Rezoning Transportation Analysis

Petition Number: 2022-205

Date	Description
4-27-23	First Review (TM)

Rezoning Plan
Petition # 2022-205

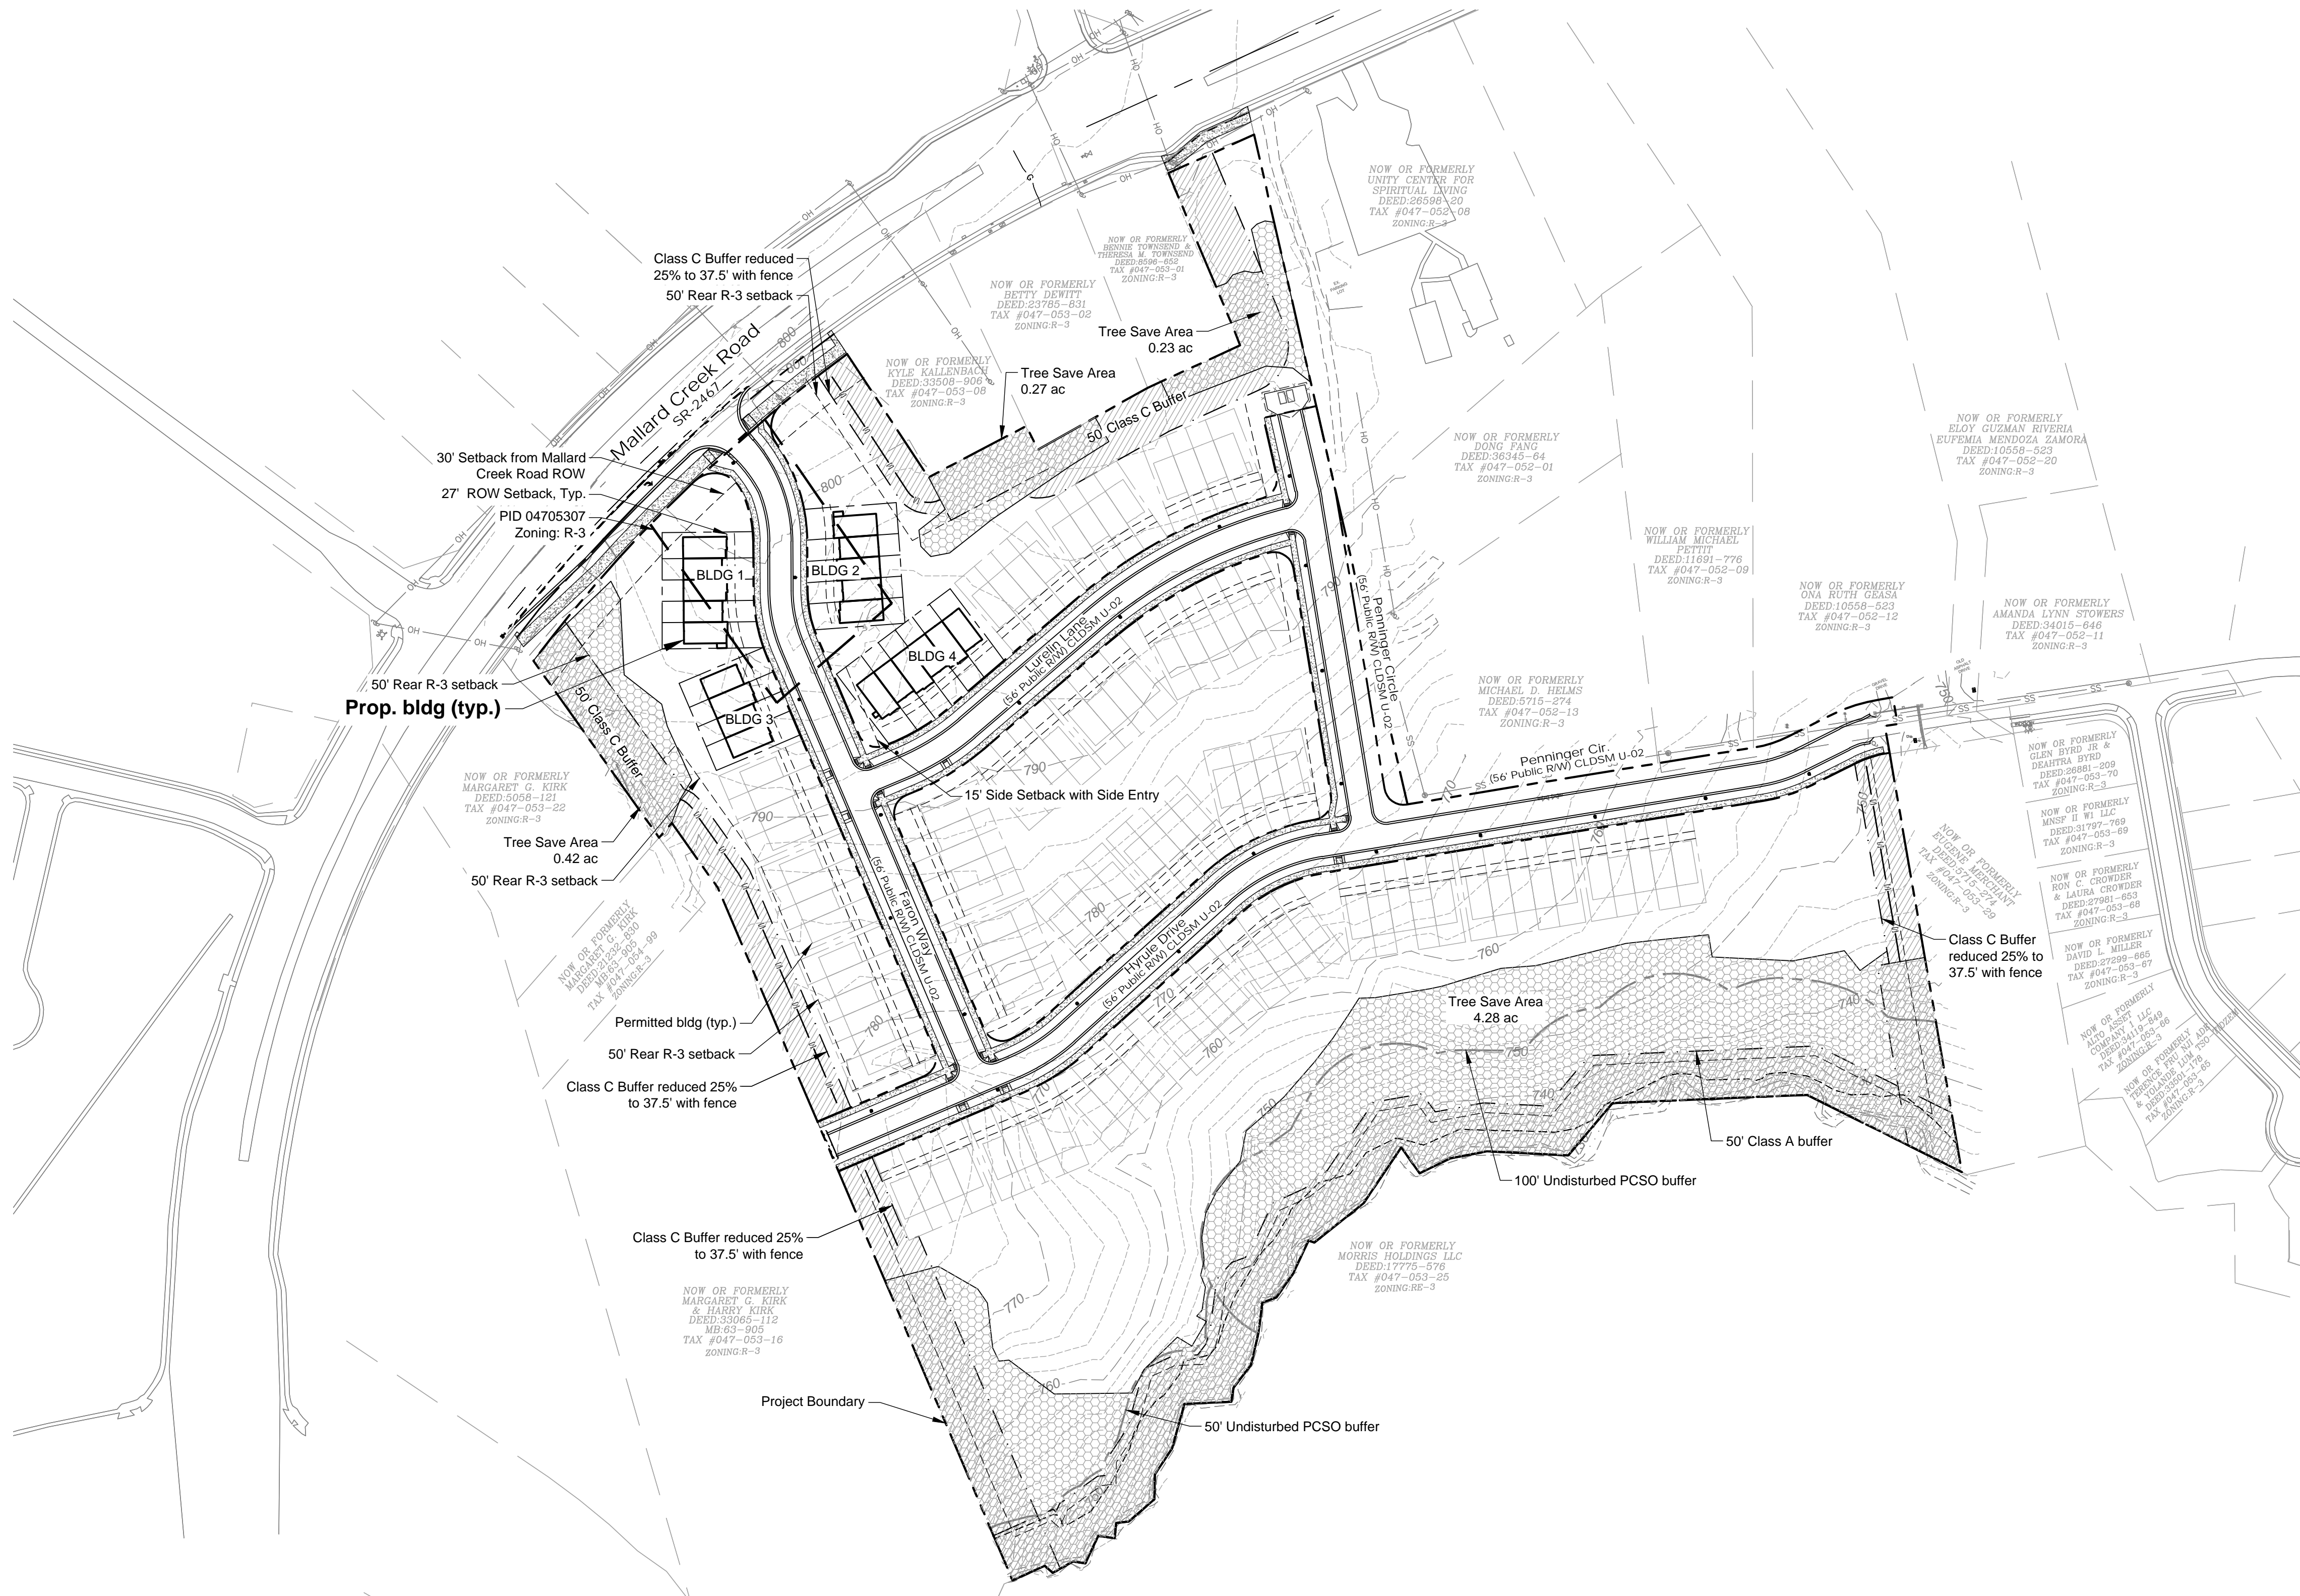
- Mallard Creek Road:** Location of curb and gutter to be moved to 33-feet from roadway centerline to accommodate the Charlotte Streets Map with a roadway typical section of 4+ Boulevard, Shared Use Path.

Label and dimension the curb and gutter from the centerline for each road on the site plan.

- Revise site plan and conditional note(s) to commit to dedicate 50-feet of right-of-way from the road centerline. The site plan shall label and dimension the right-of-way from the road centerline.

- Add a conditional note specifying "A Right-of-Way Encroachment Agreement is required for the installation of any non-standard item(s) (irrigation systems, decorative concrete pavement, brick pavers, etc.) within a proposed/existing City-maintained street right-of-way by a private individual, group, business, or homeowner's/business association. An encroachment agreement must be approved by CDOT prior to construction/installation. Contact CDOT for additional information concerning cost, submittal, and liability insurance coverage requirements."

- Add a conditional note specifying "The petitioner needs to complete and submit the [Right of way Abandonment Petition form](#) to CDOT for review. The Right of Way Abandonment process is controlled by North Carolina General Statutes and is independent of this rezoning process."

- Add conditional note specifying "All public roadway improvements will be subject to the standards and criteria of CDOT and NCDOT, as applicable, to the roadway improvements within their respective road system authority. It is understood that such improvements may be undertaken by the Petitioner on its own or in conjunction with other development or roadway projects taking place within the broad north
